Engineers Comments Regarding Surface Water Drainage

Application No: CM/34/21/PL

Site Address: Maidenhead Aquatics Crookthorn Lane Climping BN17 5SN

Description of Works: Change of use of part of site to car wash including siting of cabin and canopy. This application may affect the setting of a listed building & is in CIL Zone 5 (Zero Rated) as other development.

Ground Floor Plans

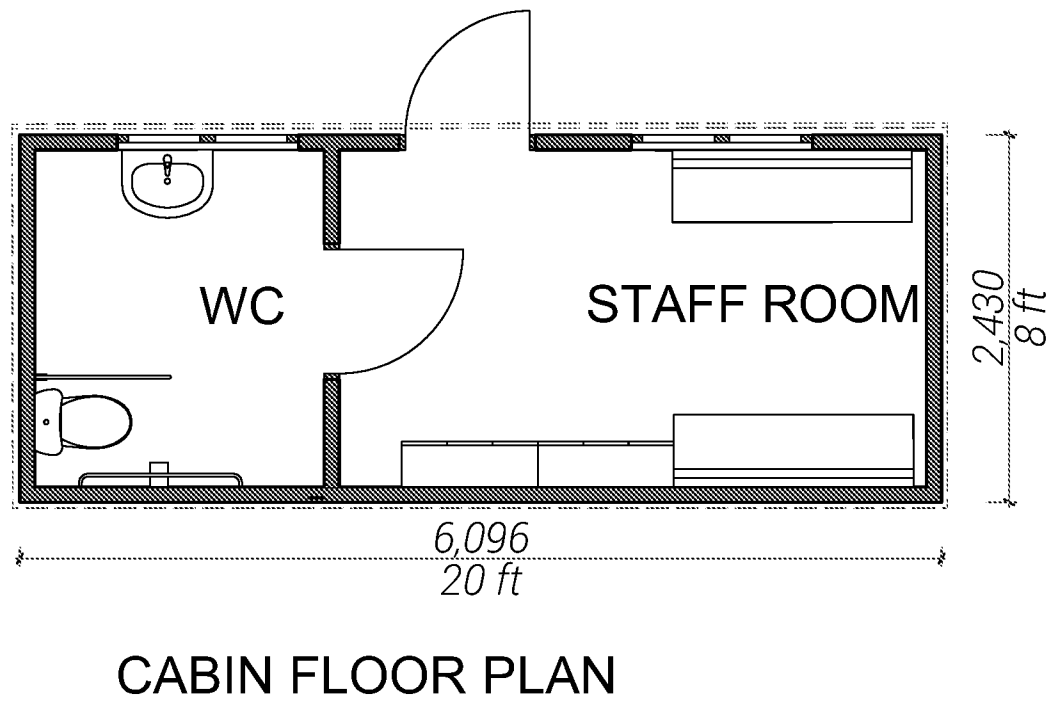
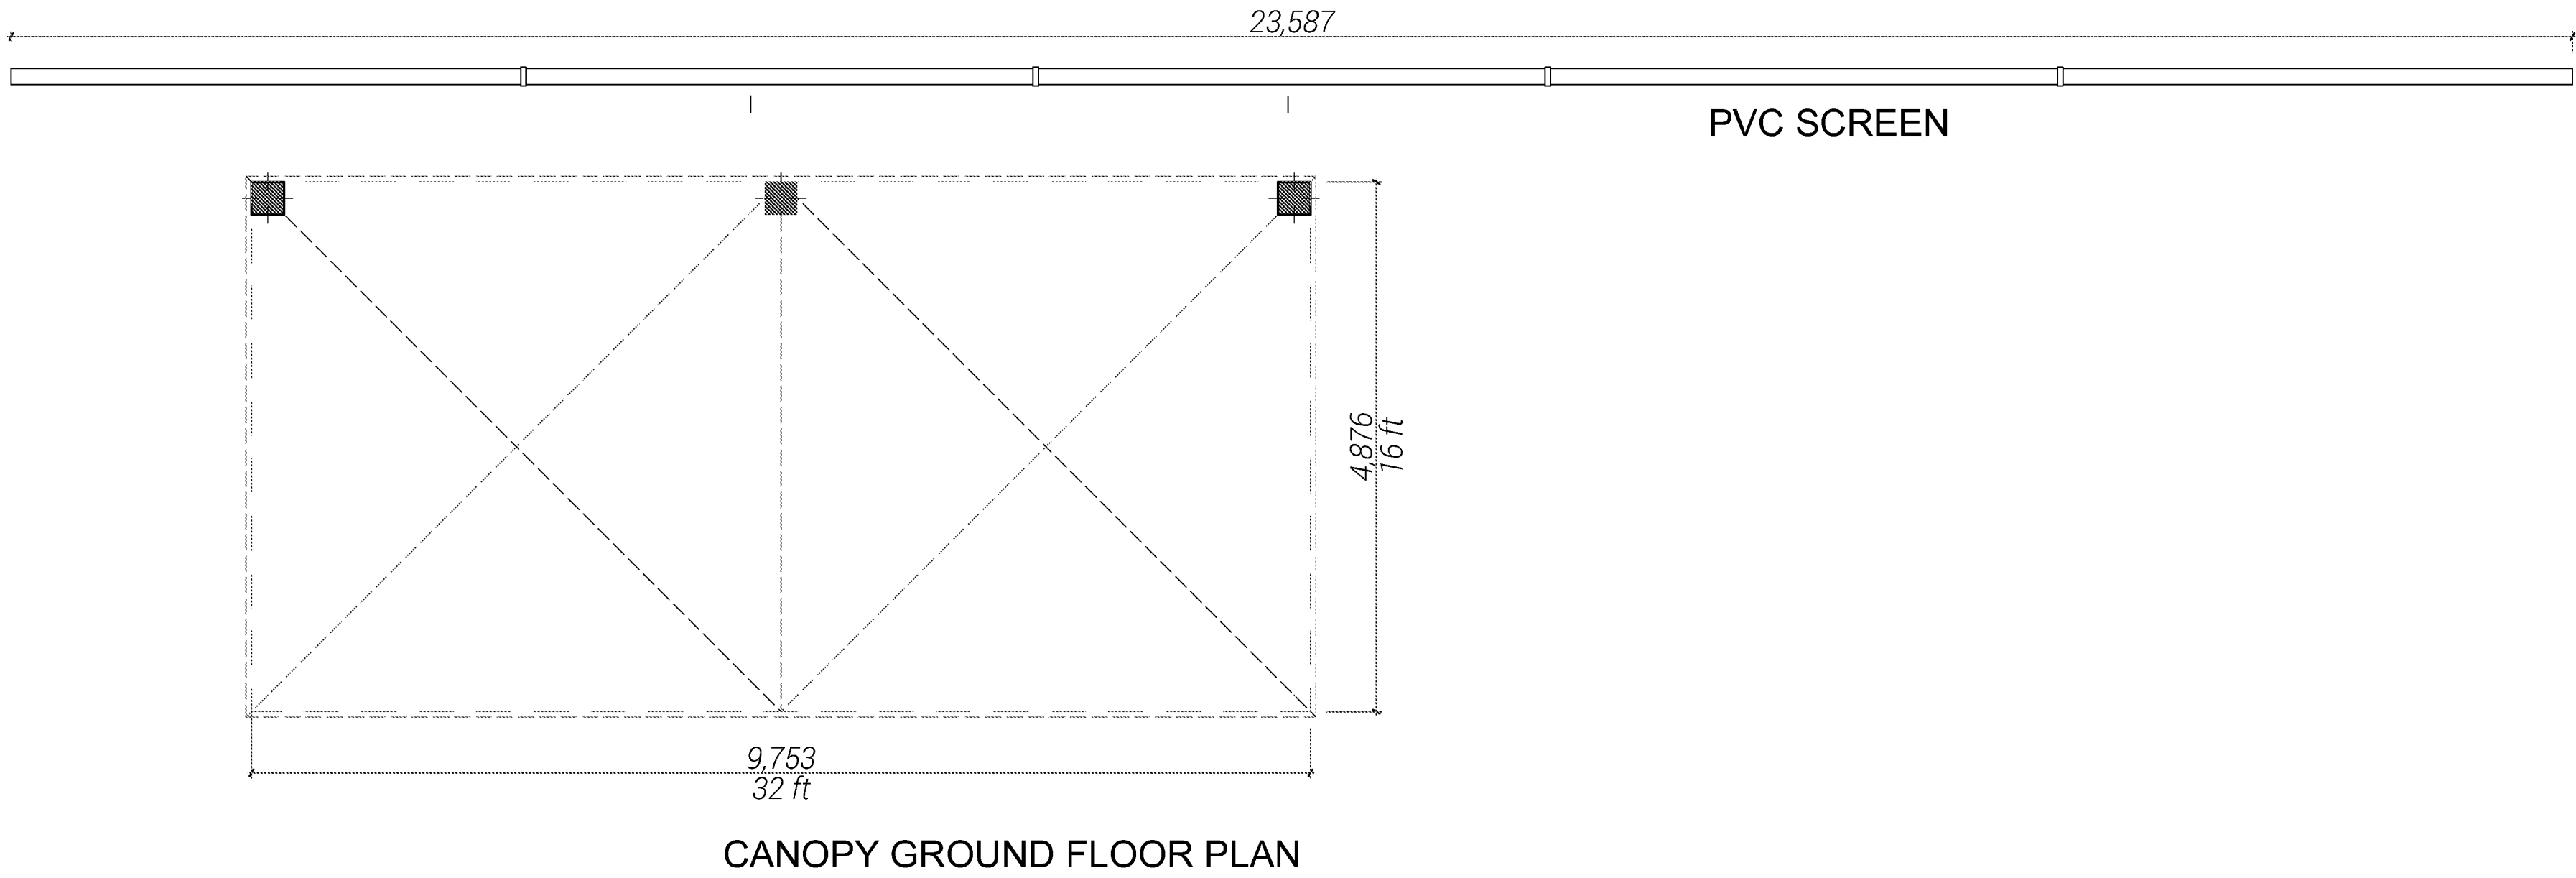
It is worth noting that the washdown area will need to discharge to the foul sewer with an appropriate trade effluent license. We would expect details of how the waste water will be treated and separated from surface water on site to be provided and agreed by Southern Water. I would expect an appropriate condition to this effect to be requested by Southern Water and/or applied by the Planning Authority considering the application location in the Lidsey Treatment Catchment.
